# Response to ABP Opinion

## Kilternan Village SHD

In respect of a Strategic Housing Development comprising 383 No. residential units and a Neighbourhood Centre

At lands at Wayside, Enniskerry Road and Glenamuck Road, Kilternan, Dublin 18

DATE:	JUN. 22	DRAWN BY:	LQMD
SCALE:	1:1000@A1	REVISION:	
JOB NO.:	21009	DRAWING NO.:	PL105

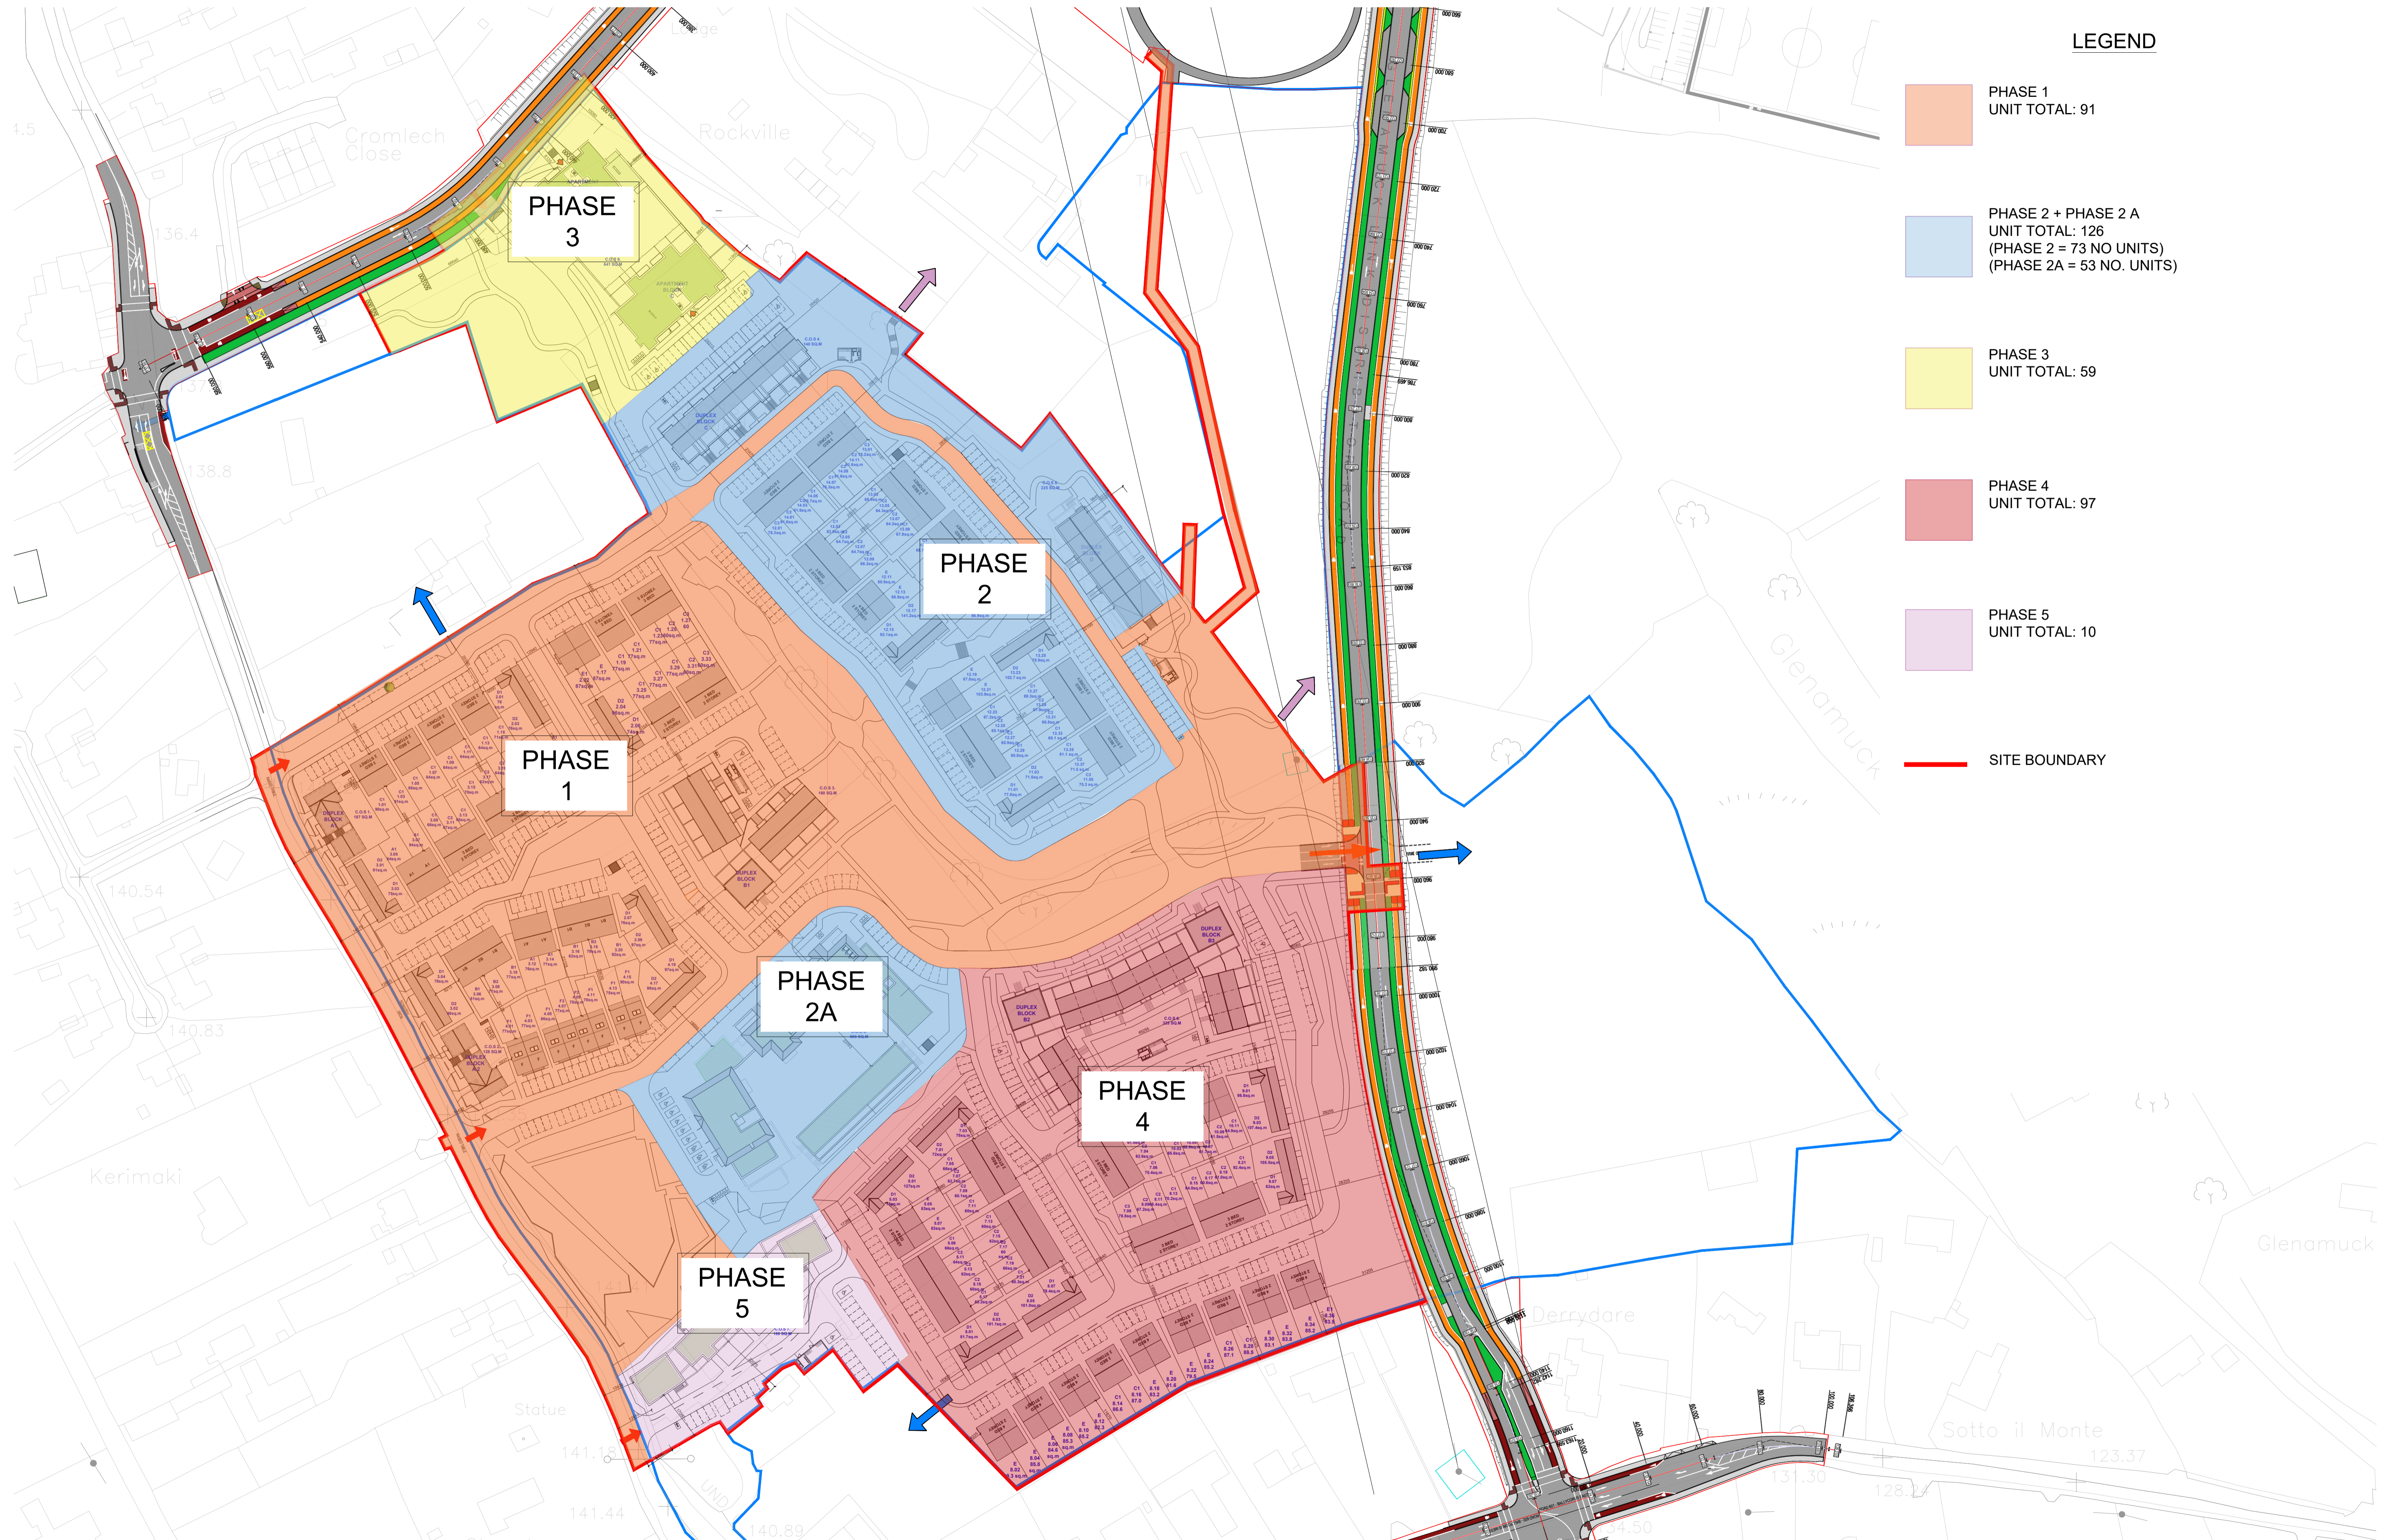
*'A detailed statement demonstrating how the proposed development ties in with the wider development strategy for the landholding and the overall Kiltiernan Area, with regard to a phasing strategy.'*

Please see below the proposed phasing timelines for the proposed development which demonstrates the timeline for development on site and how it ties into the overall Kiltiernan Area:

Phase	Units	Months	Start Month	Completion
Phase 1	91	18	Apr-23	Sep-24
Phase 2	73	24	Apr-24	Mar-26
Phase 2a (Neighbourhood Centre)	53			
Phase 3	59	12	Aug-25	Jul-26
Phase 4	97	18	Feb-26	Apr-28
Phase 5 (Retail & Community)	10	8	Sep-27	Apr-28
<b>Total</b>	<b>383</b>	<b>80</b>

Phase	Other works in Phase
Phase 1	Including Associated drainage, Main Public Open Space, Central Green Way Link, Dingle Way, Off-Site Drainage through Southern Lands - Form Access to GLDR in this phase if GLDR in place. Demolition works.
Phase 2	Form Access to new GLDR (if not completed in Phase 1) - Associated Drainage for Phase
Phase 2a (Neighbourhood Centre)	
Phase 3	Access to Glenamuck Road, and Drainage for Phase
Phase 4	Associated Drainage for Phase
Phase 5 (Retail & Community)	Associated Drainage for Phase
